Application No: WA/63/21/PL
Site Address: Land East of Tye Lane Walberton BN18 0LU
Description of works: Proposed alternative vehicular accesses off Tye Lane and emergency access off Avisford Park Road, along with minor highway works following WA/95/18/RES (resubmission following WA/93/20/PL). This site is CIL Zone 2 (Zero Rated) as other development.

Thank you for your internet representation made on 2nd August 2021 which has been recorded as an objection with the comments as follows:

Drawing Title:
PROPOSED ALTERNATIVE ACCESS

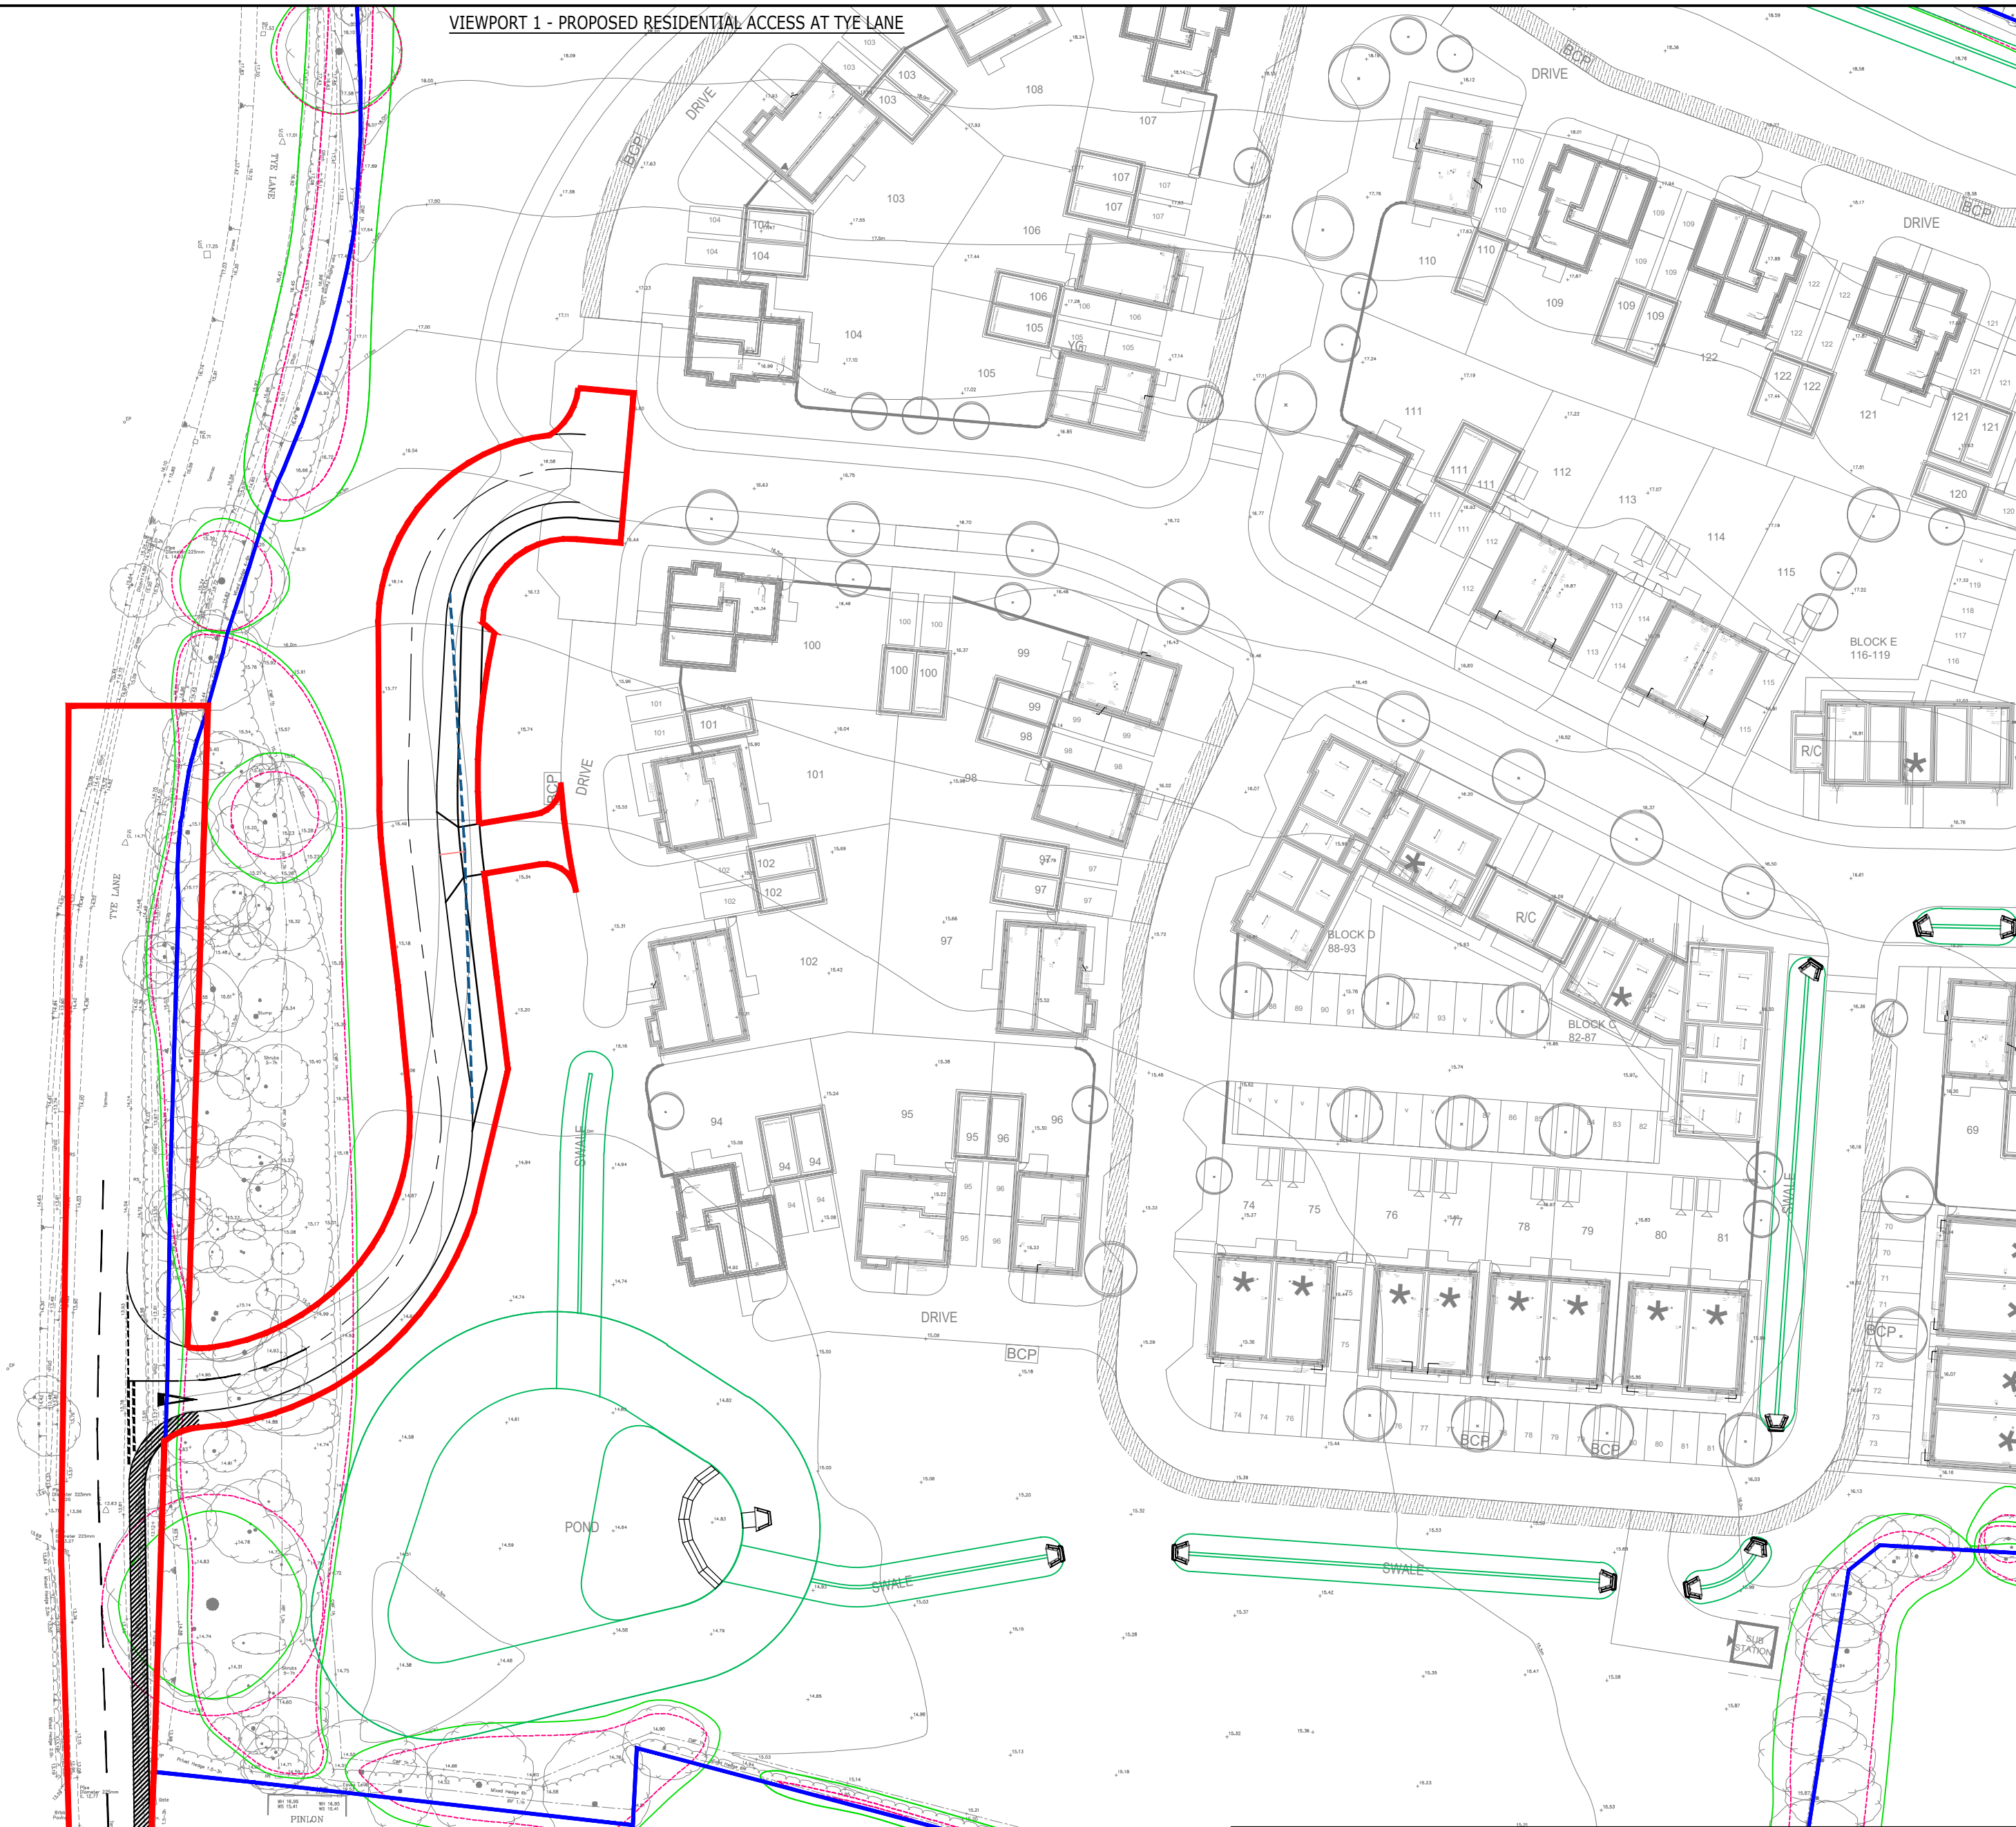
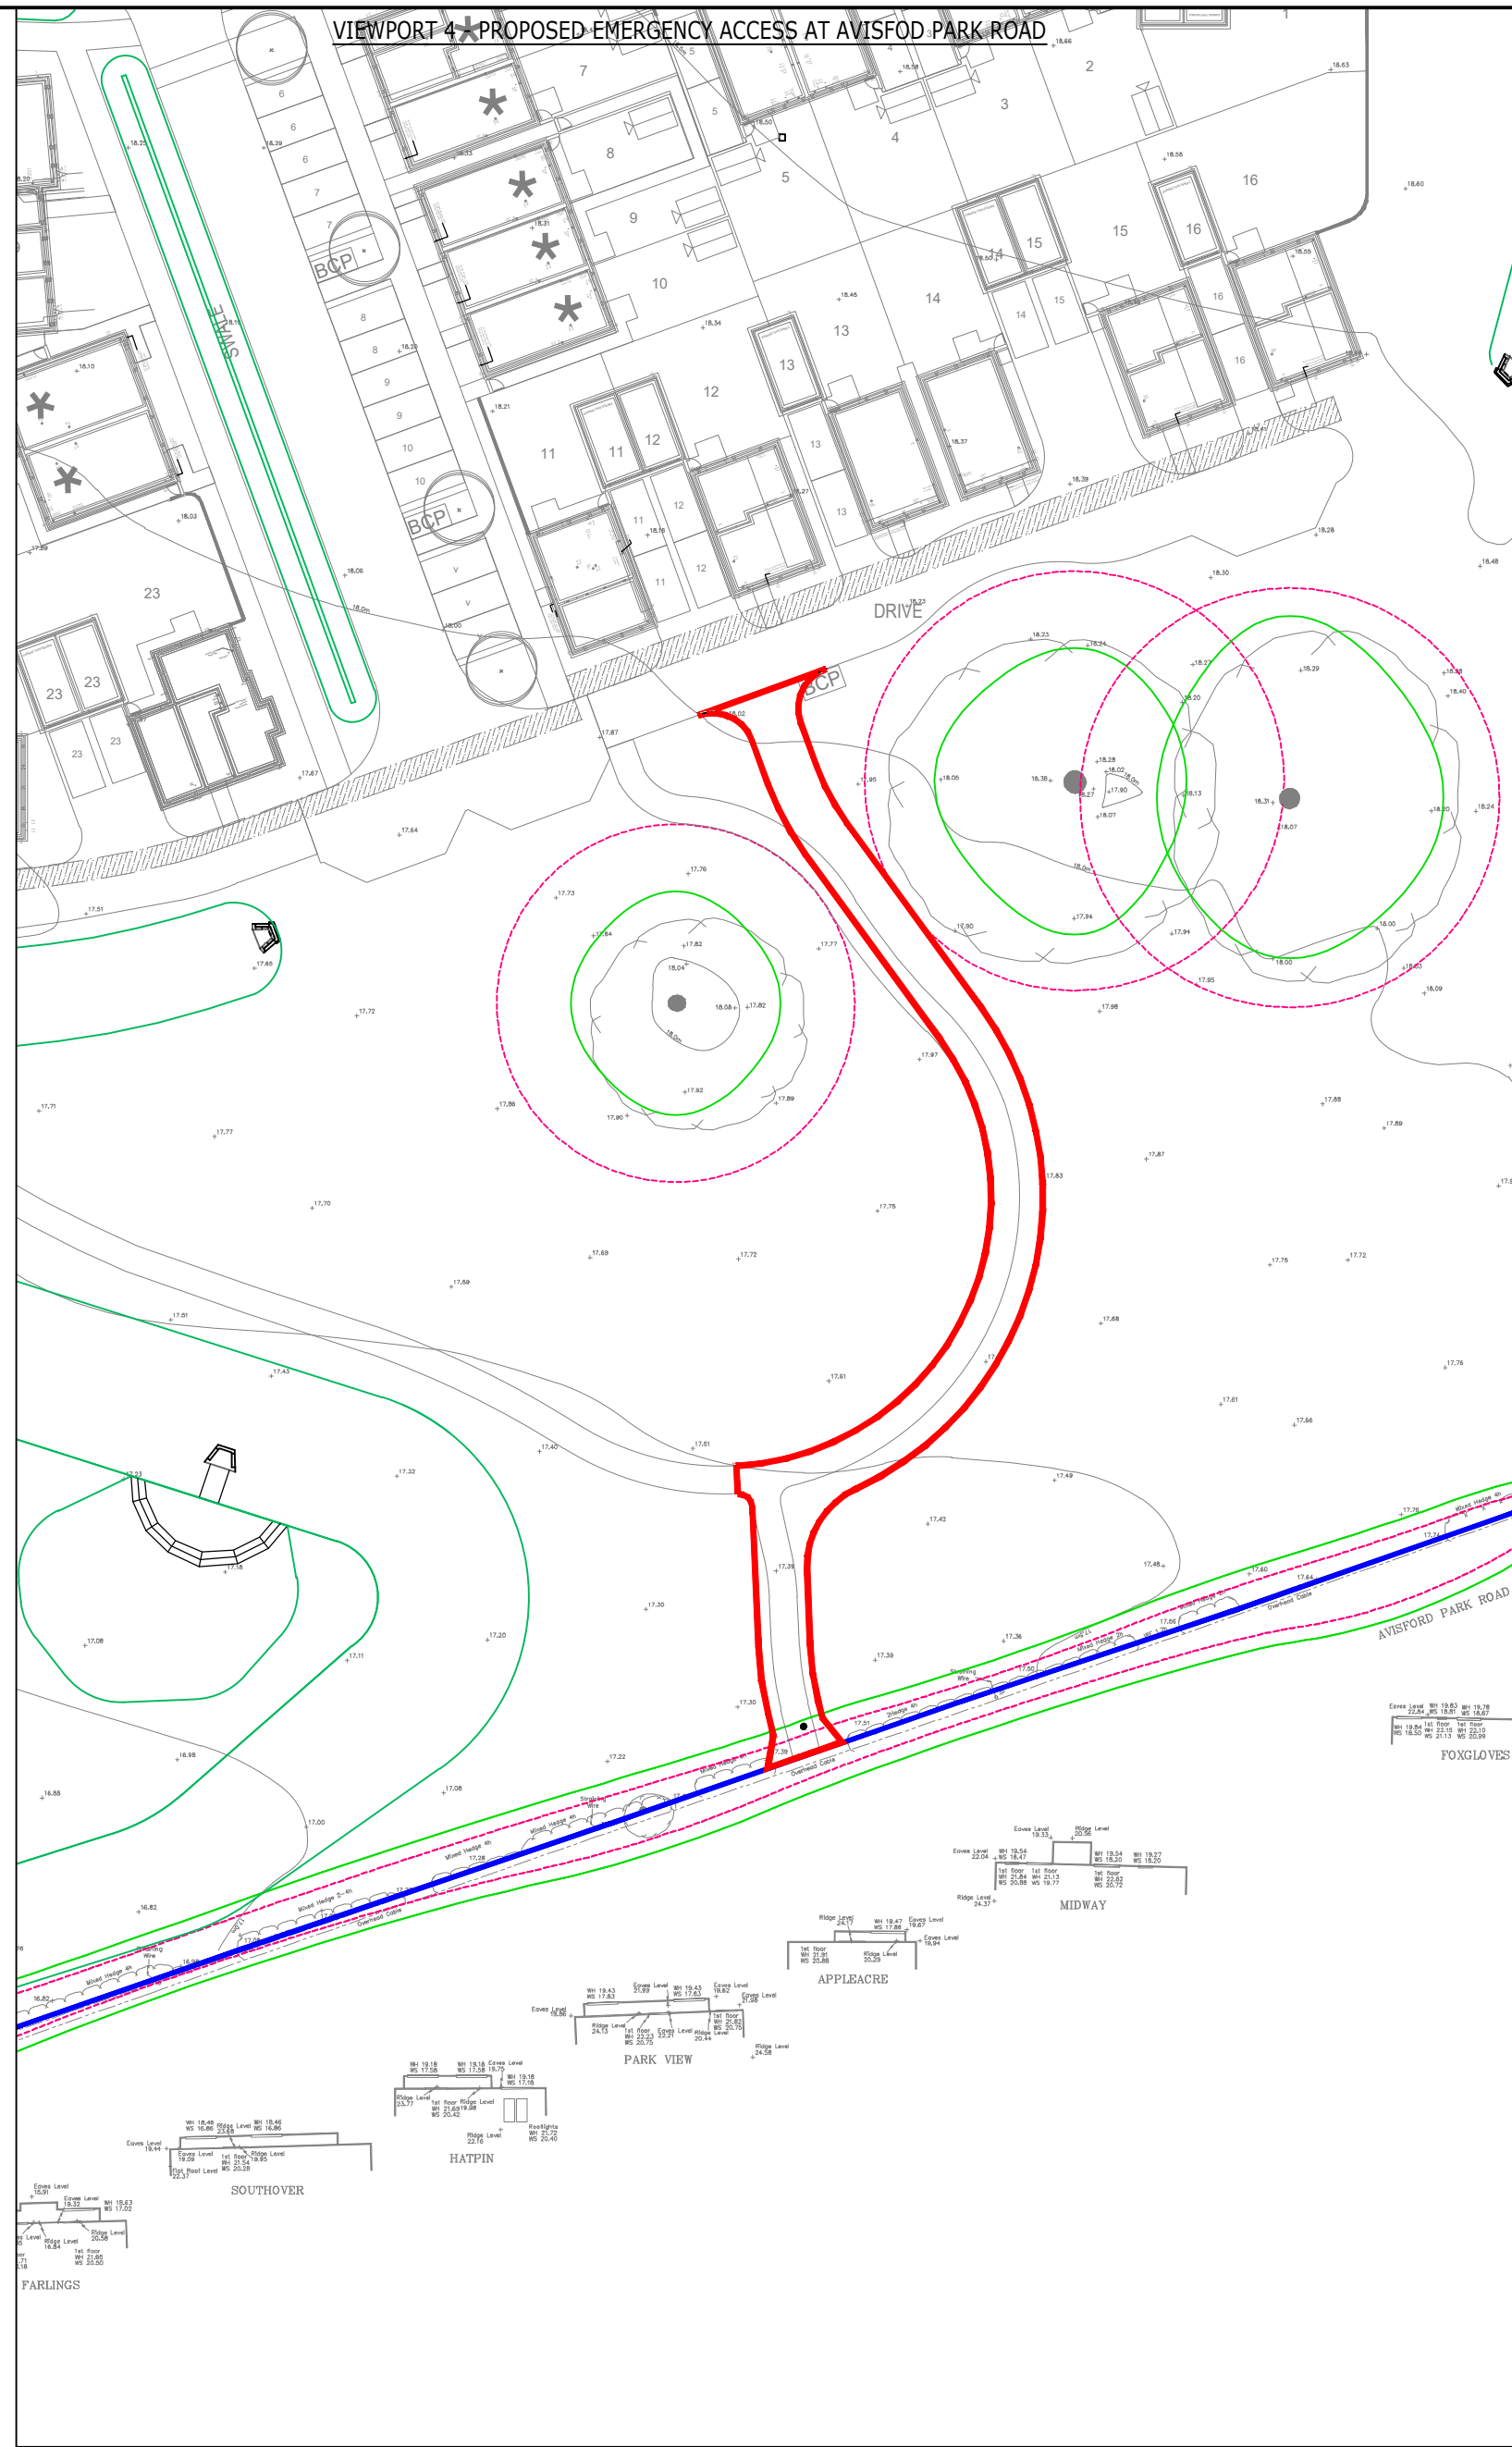
The proposed width of the modified Tye Lane still does not permit easy and safe passage of vehicles - the developers seem to be using out of date widths for their calculations.
